Application no: H04/0714/97

Description: Alterations to ground floor &
build additional bedroom
over garage

Amendment: Substitute front projecting flat roof with single pitch tile
roof (TS.L.002.01.R1)

NOTICE OF ACCEPTANCE OF AMENDMENT

Drawing No TS-1-002-01-R1

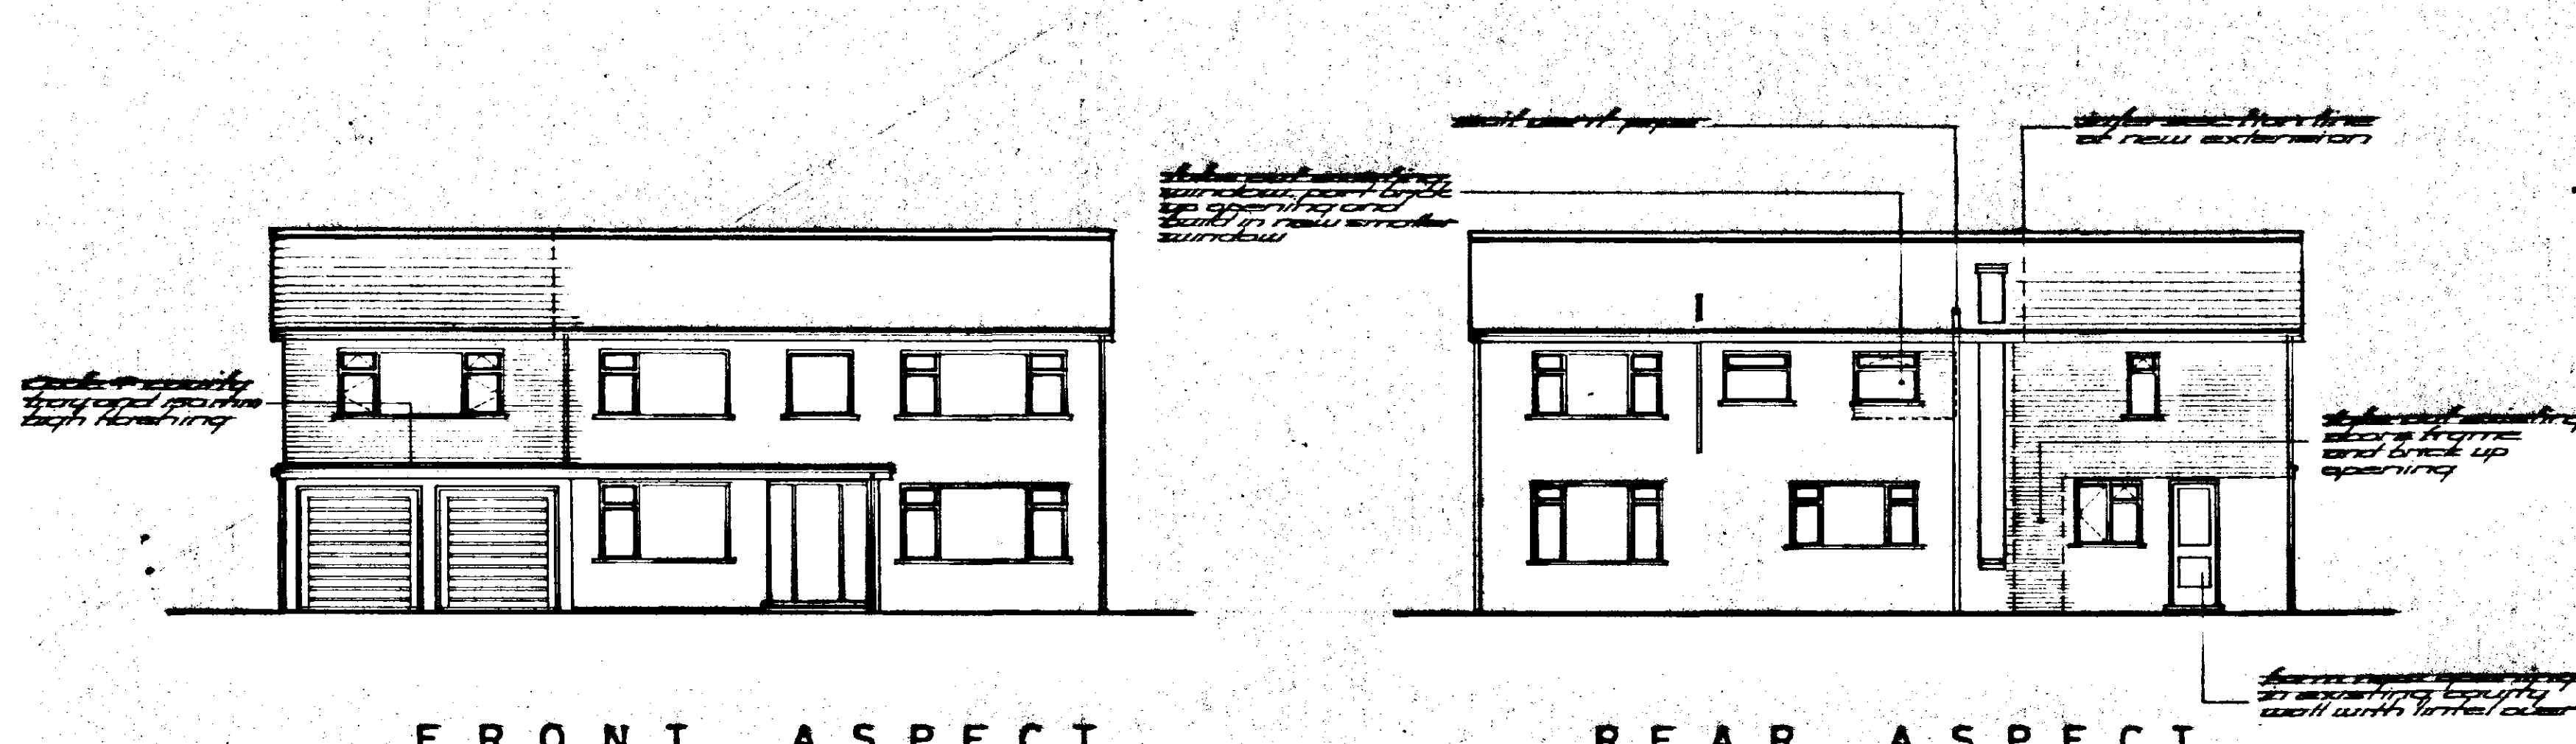
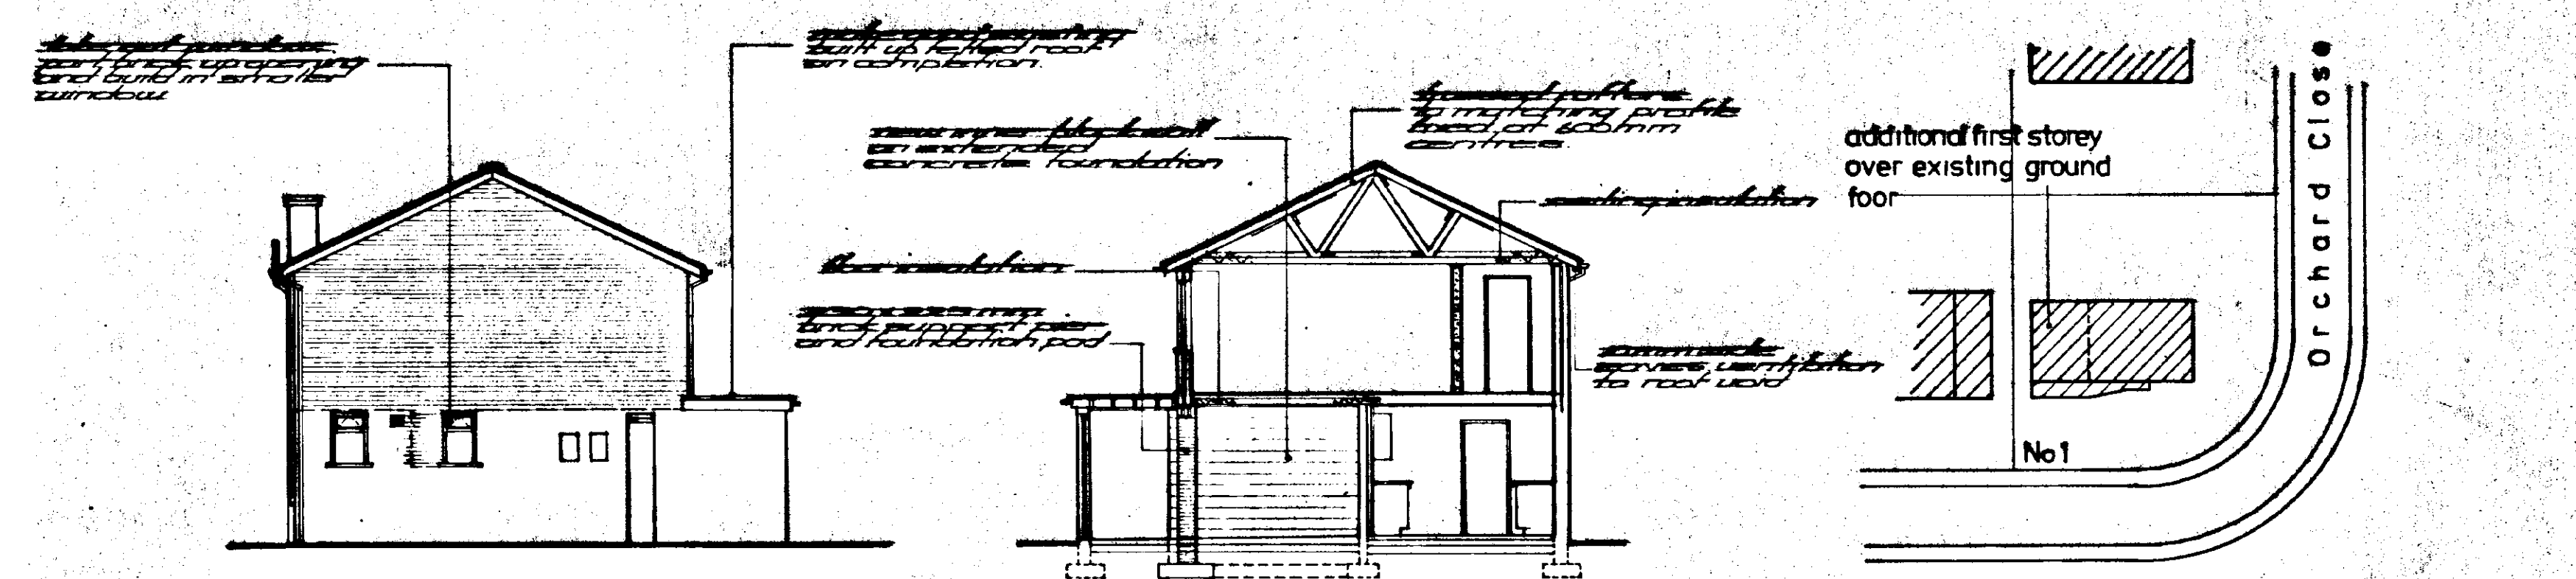
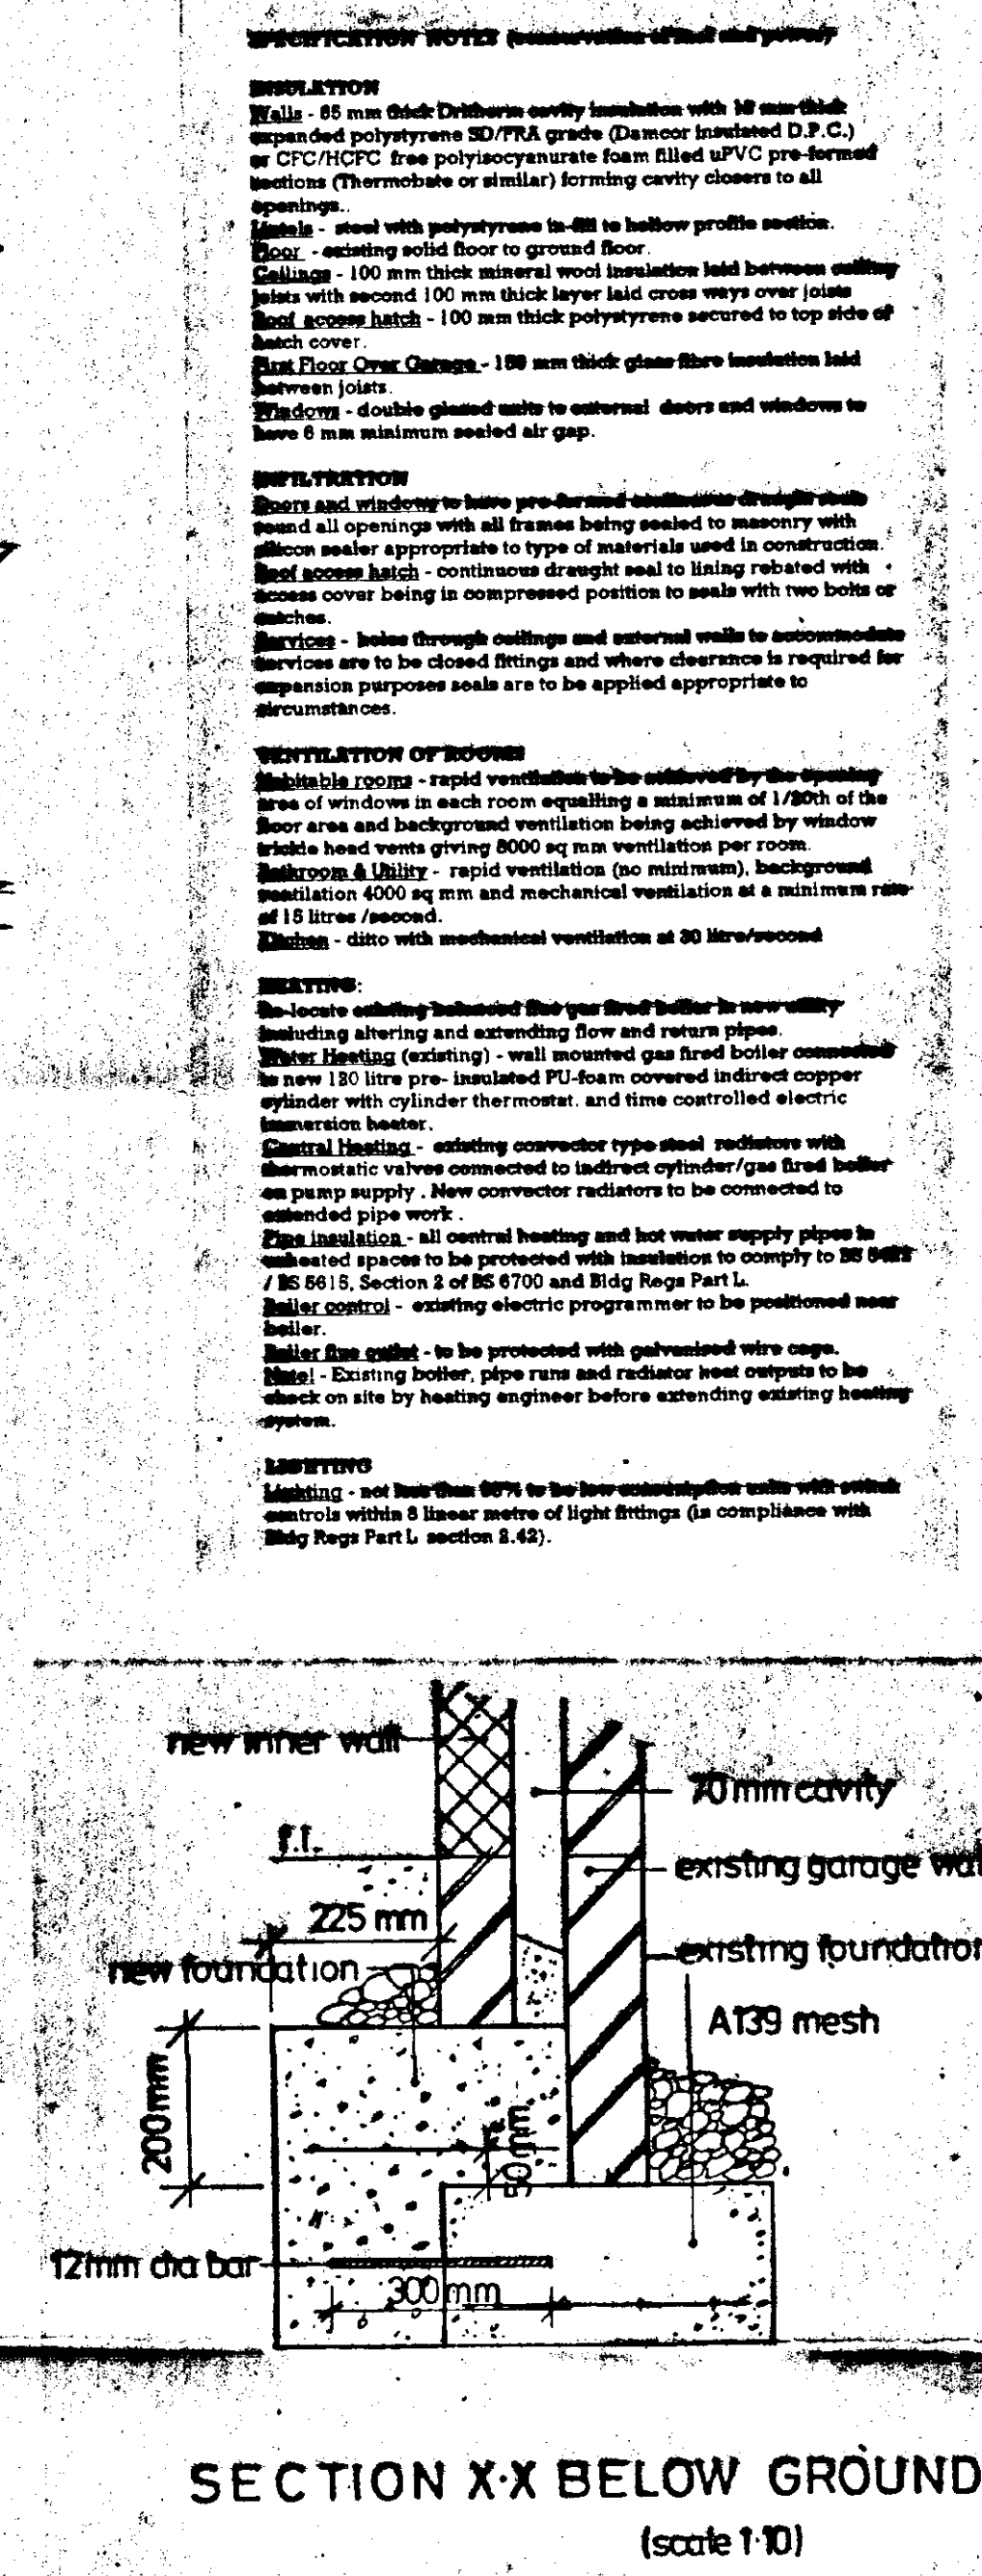
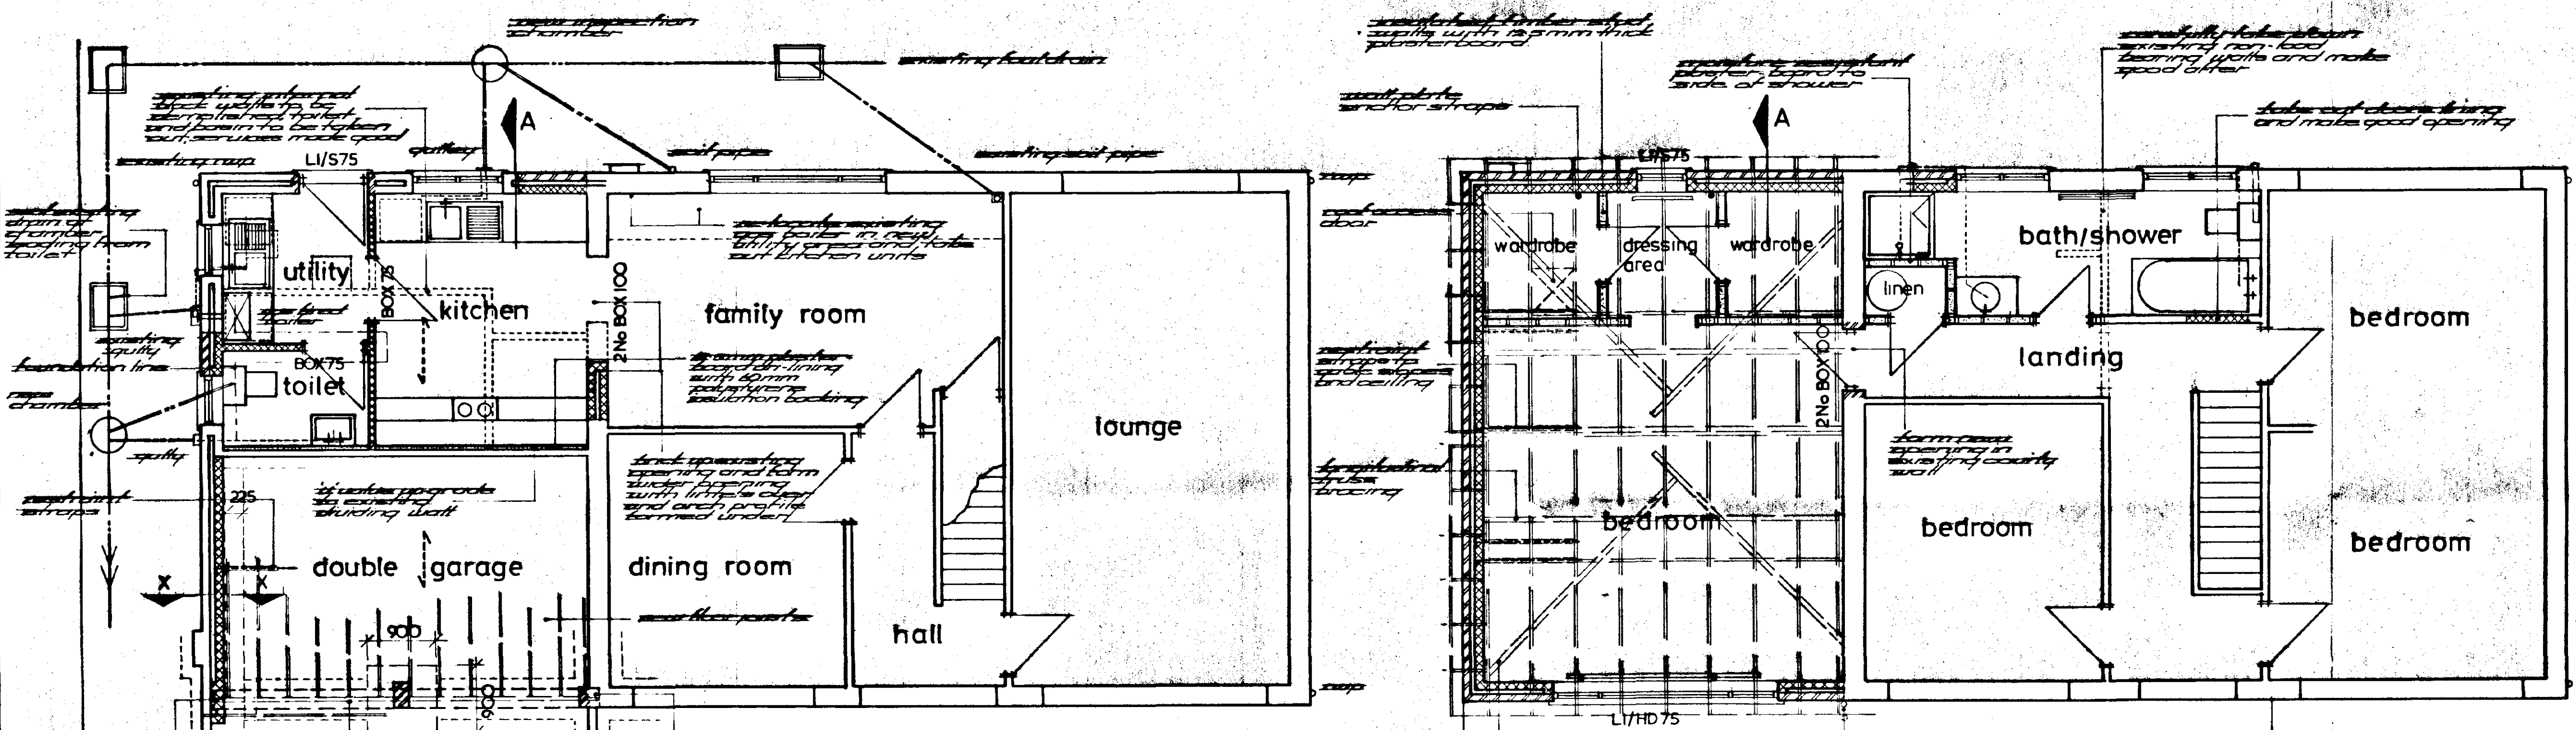
Substitute front
projecting flat roof
with single pitch
tile roof

The amended details submitted in respect of the above proposal have now been considered and there are no objections to the amendment being implemented to the extent described above.
